Comment from Greenspace

This application is looking for the discharge of Condition 11 of application P/43/18/DOC imposed under P/76/16/PL.

APPLICATION P/43/18/DOC

Description of Works: Approval of details reserved by condition imposed under P/76/16/PL relating to condition 11-proposed wetland & associated landscaping.

client	BARFOOTS OF BOTLEY LTD.		
project	Proposed Production Facility Setter Farm		
title	Constructed Wetland Draft Layout		
date	scale @ A1	drawn	chkd
Sep. 2017	as shown	GBC	
project no.	drawing no.	rev	
1603	017	07

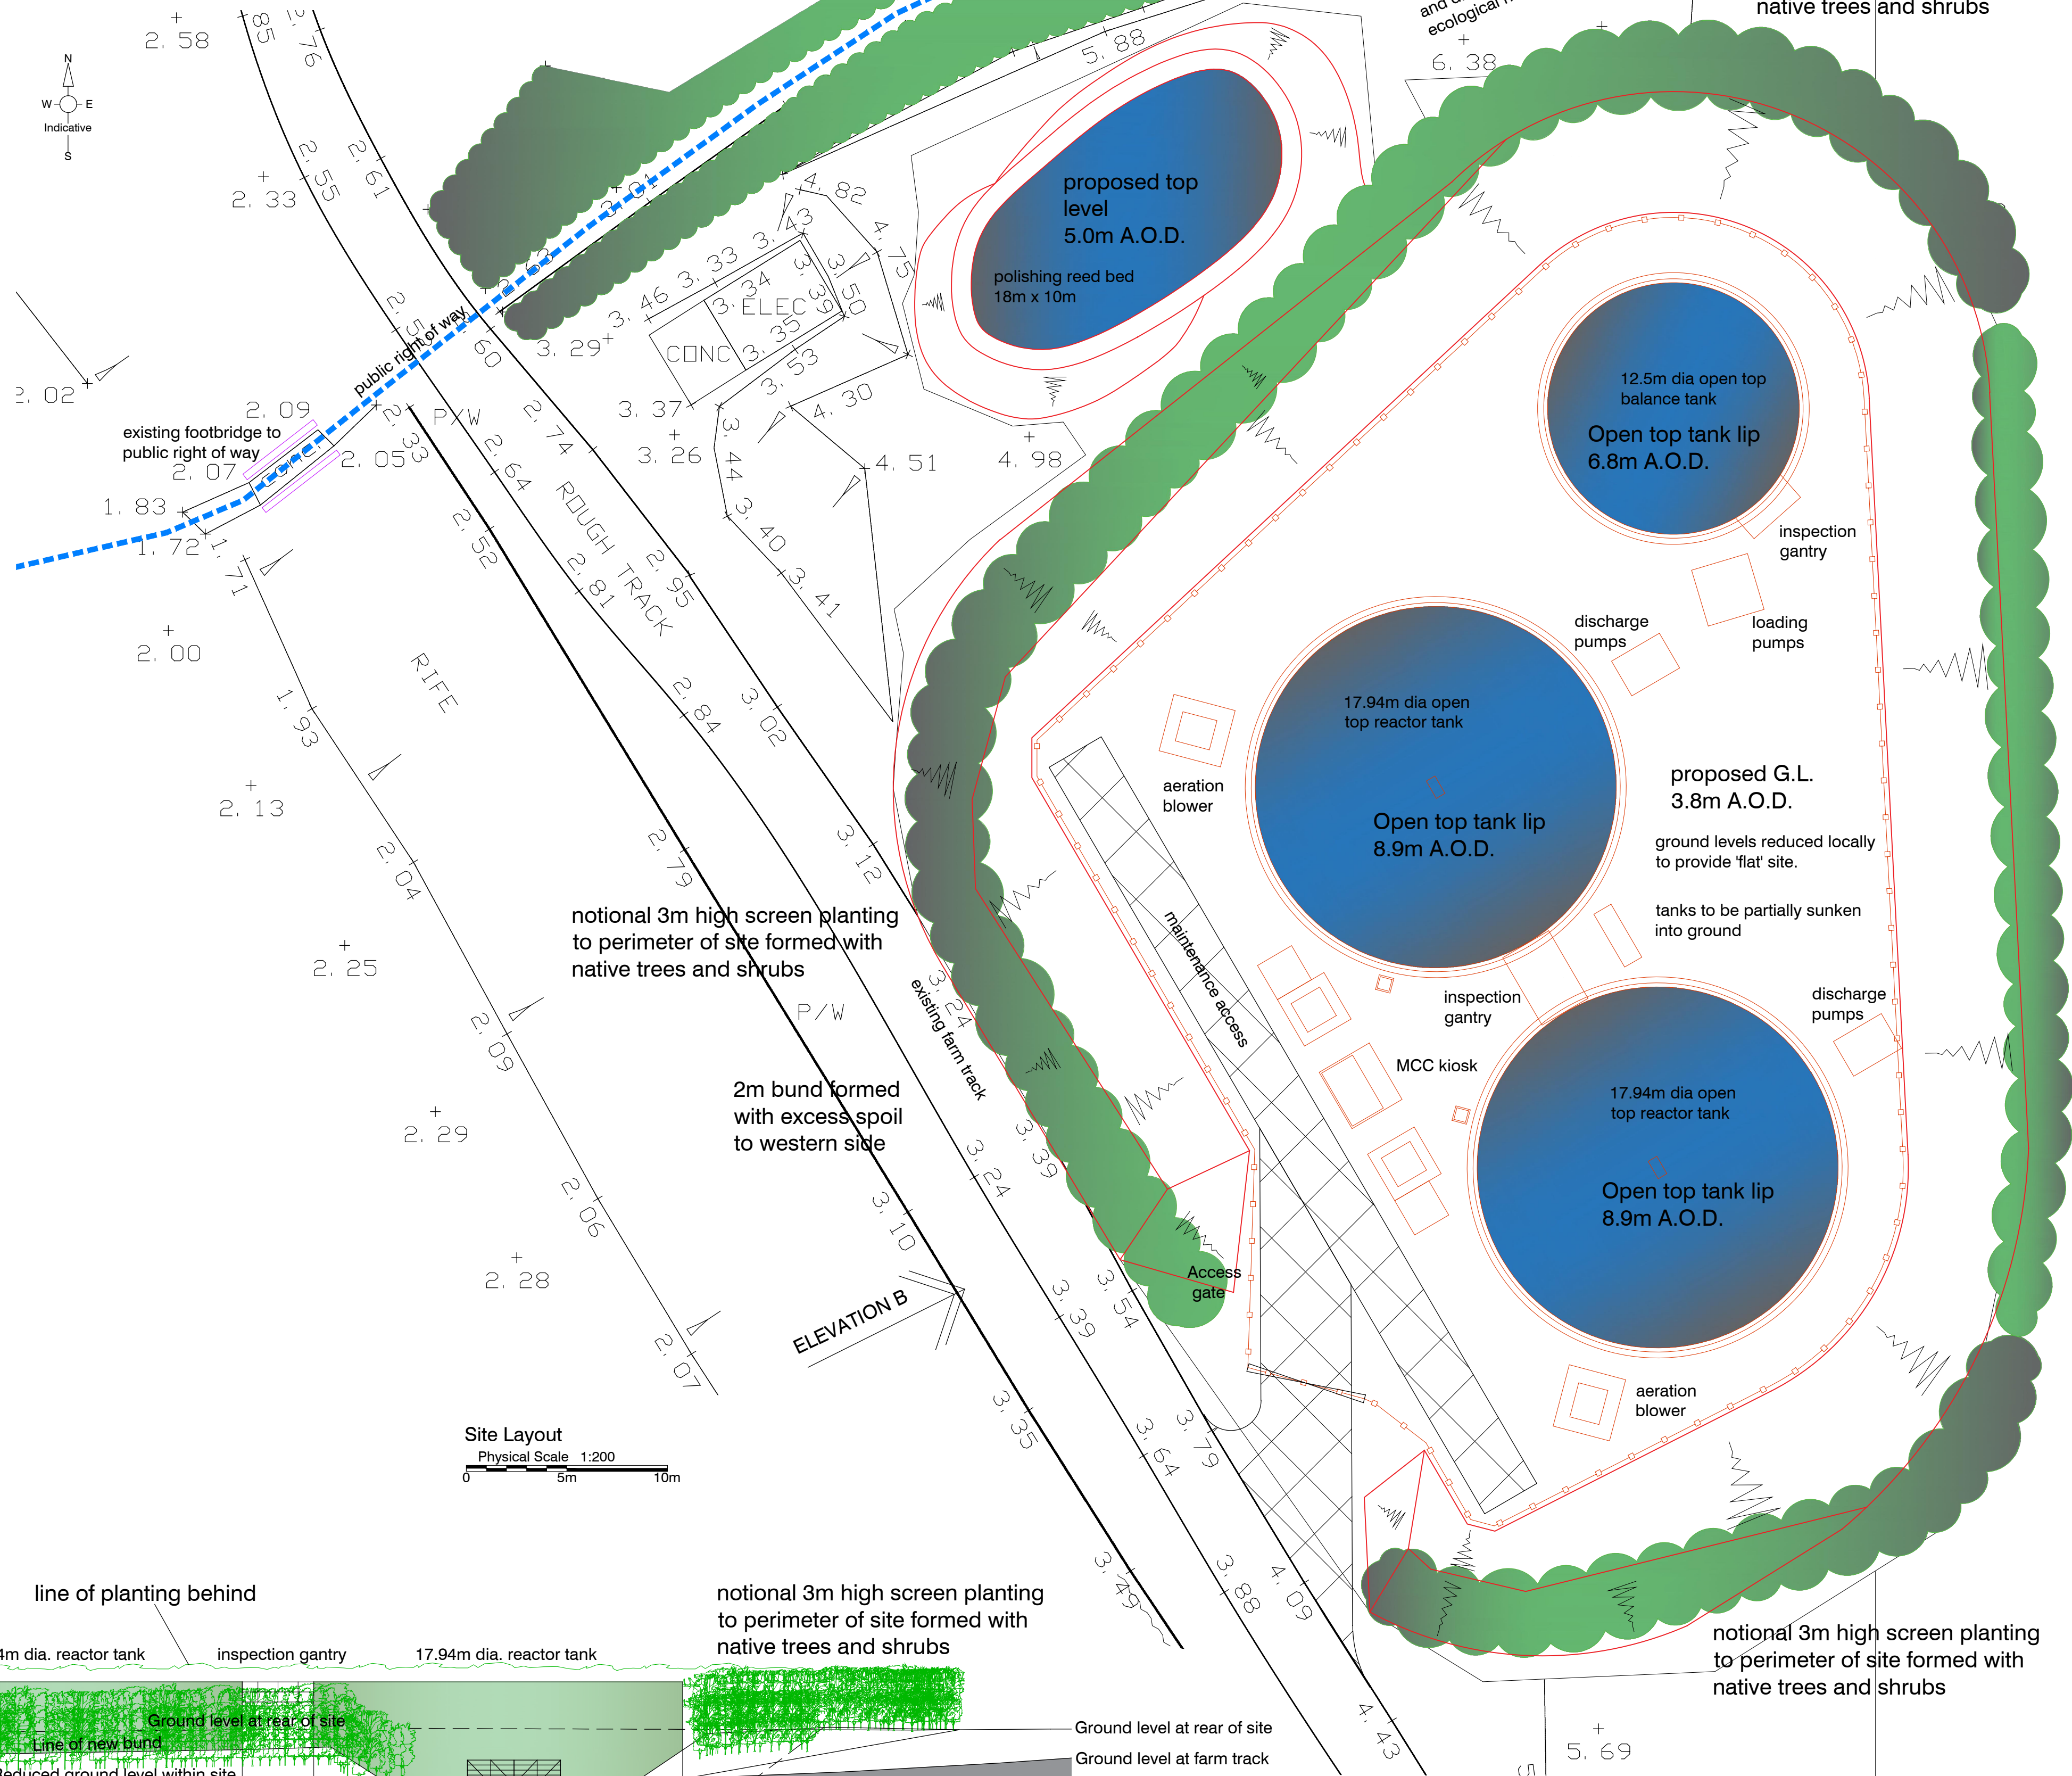
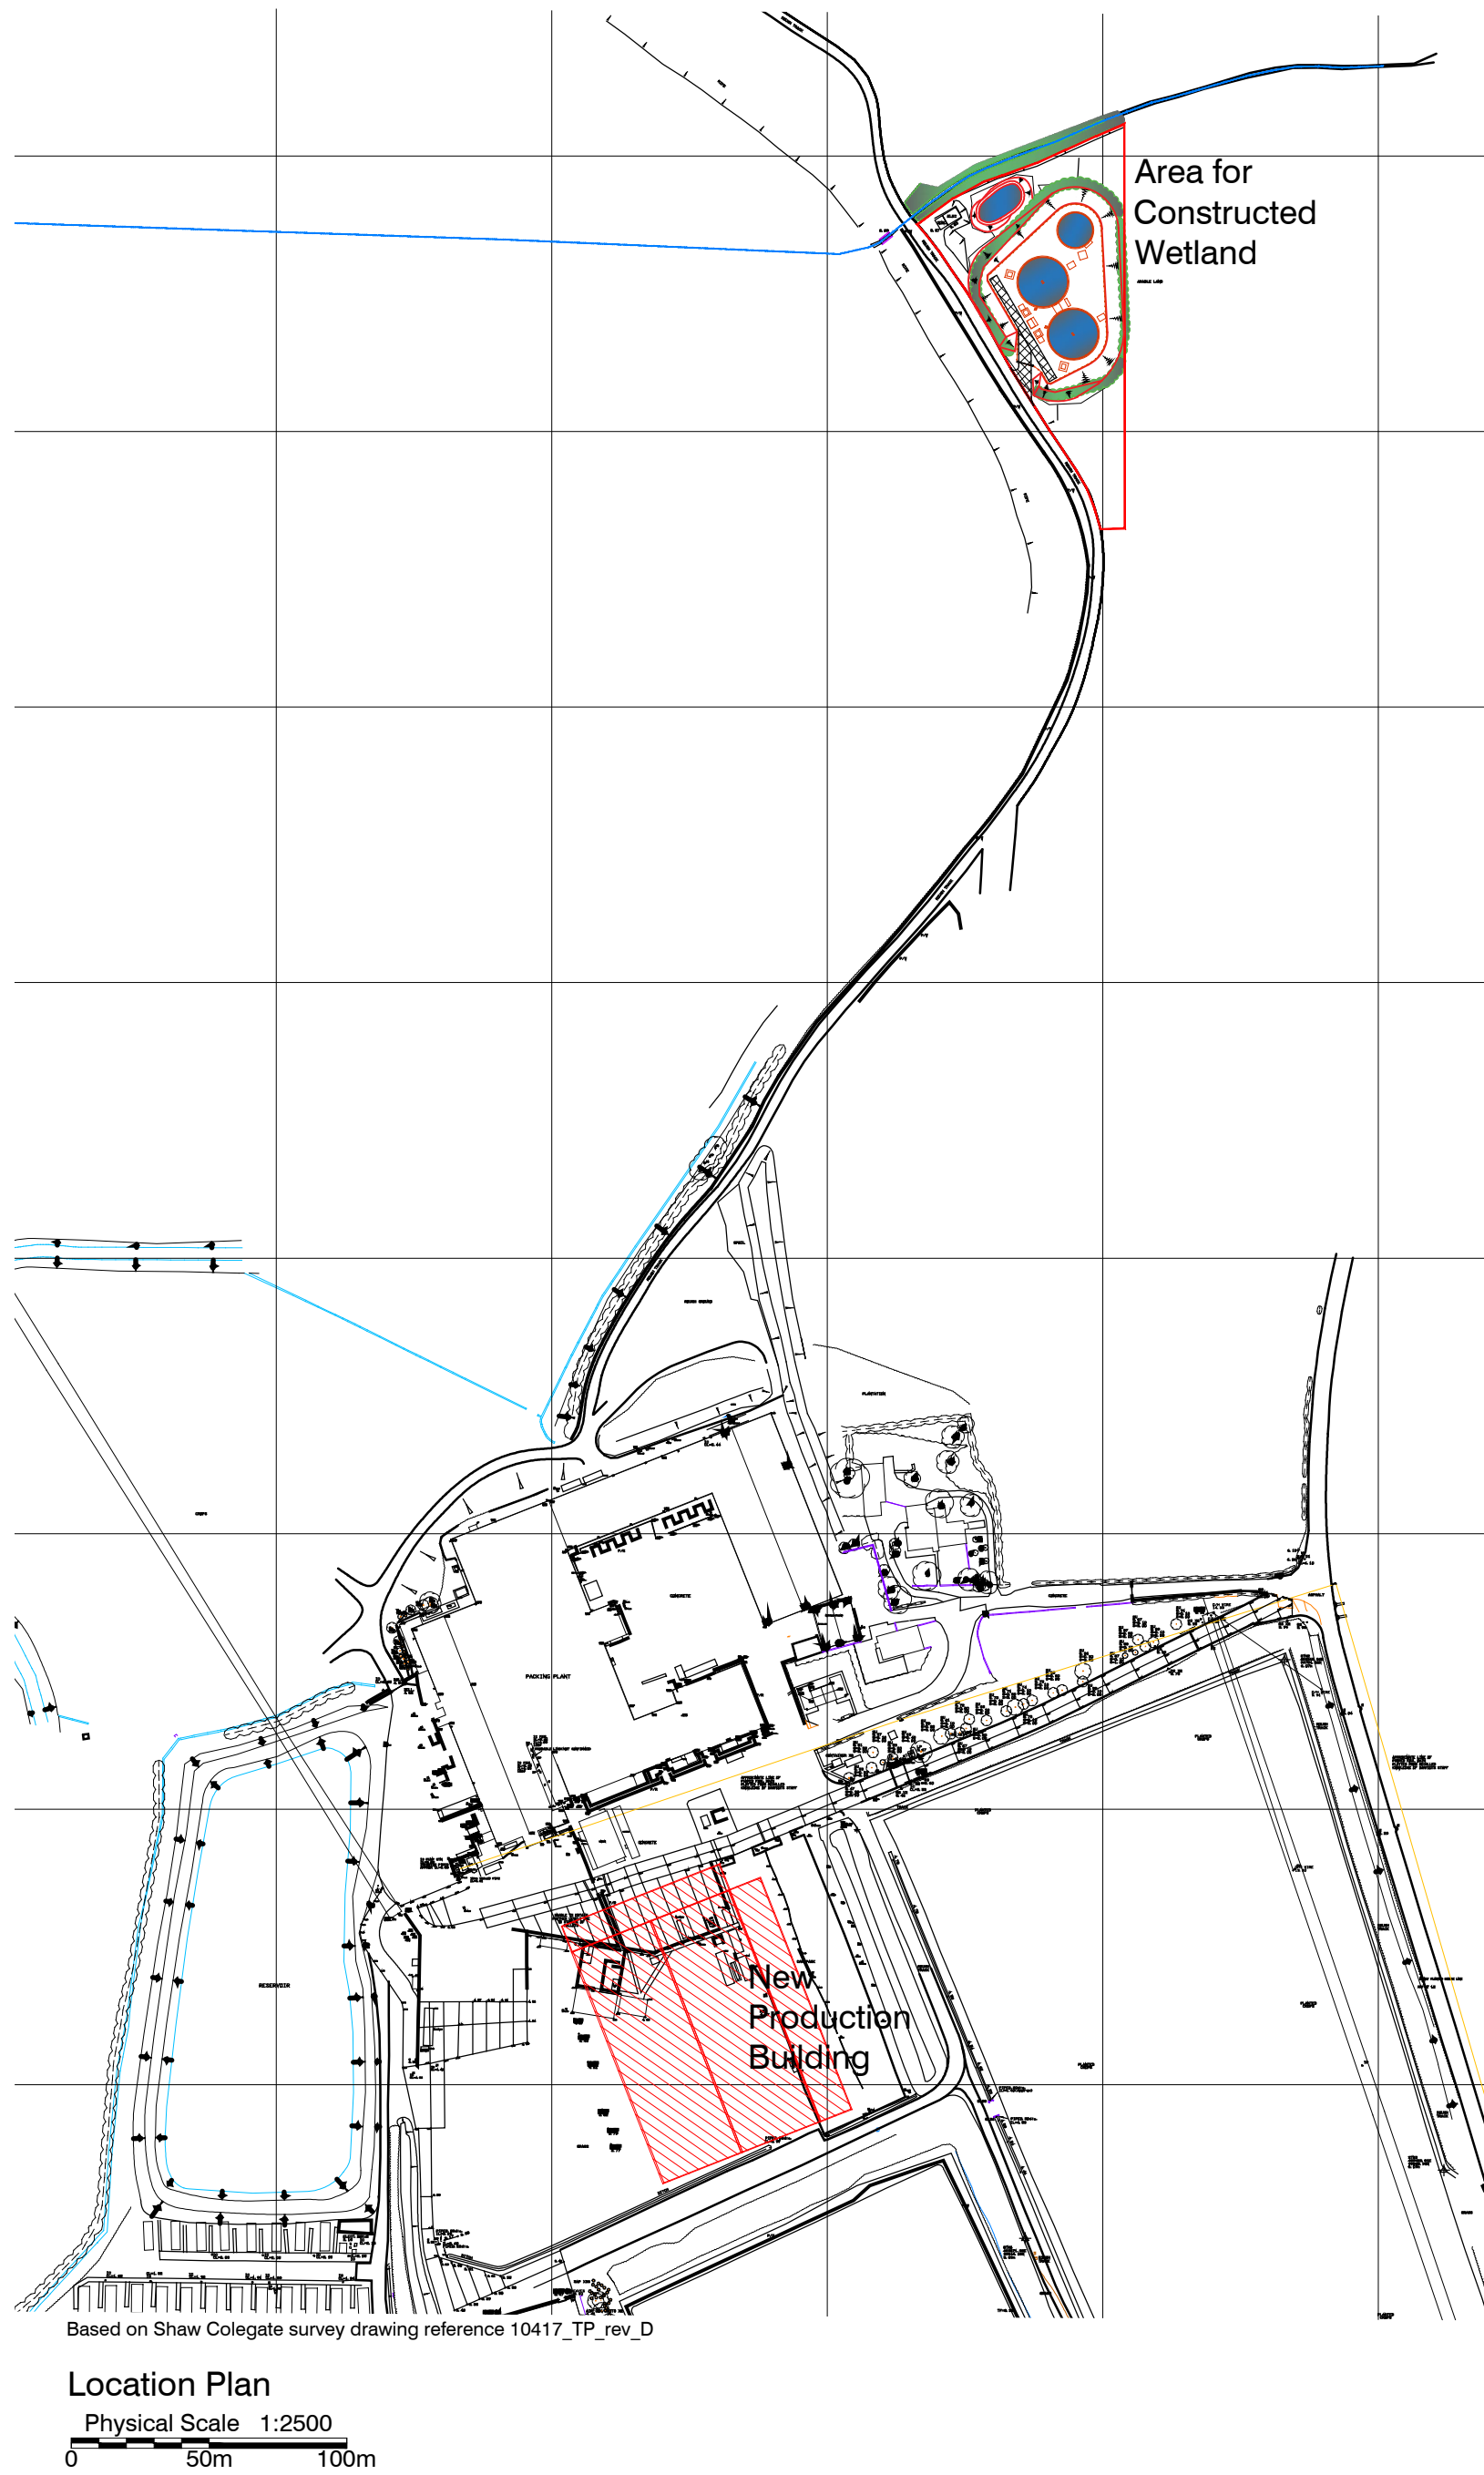
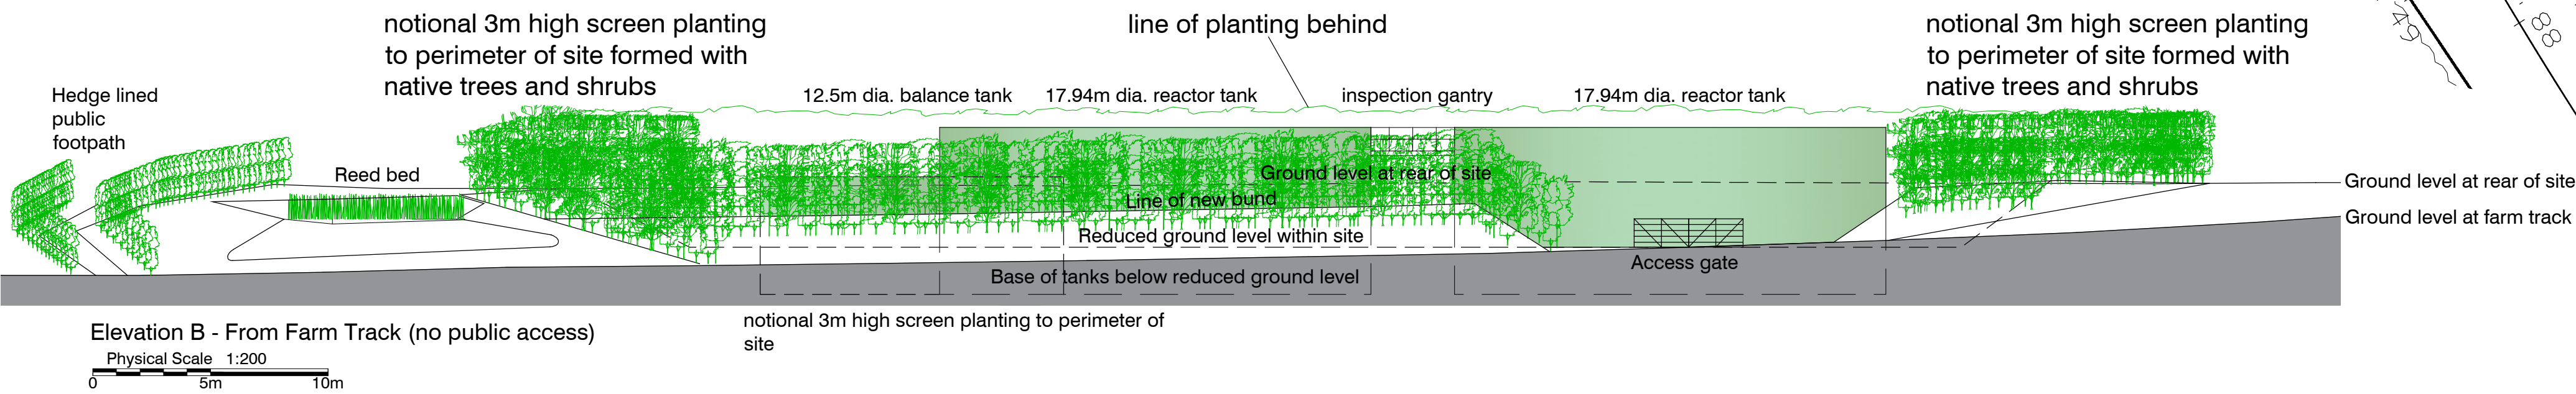
The information provided in Constructed Wetland Draft Layout dwg 017 rev 07 details an indicative screen planting to the perimeter which is shown as native planting. Whilst this is suitable for location the detail is not sufficient enough and needs to detail in plan form actual species choice, planting density and size at time of planting. This information needs to be submitted for approval before condition 11 re Landscaping can be considered for discharge.

We would therefore **not recommend the discharge of Condition 11 landscape scheme until the above information has been submitted for approval.**
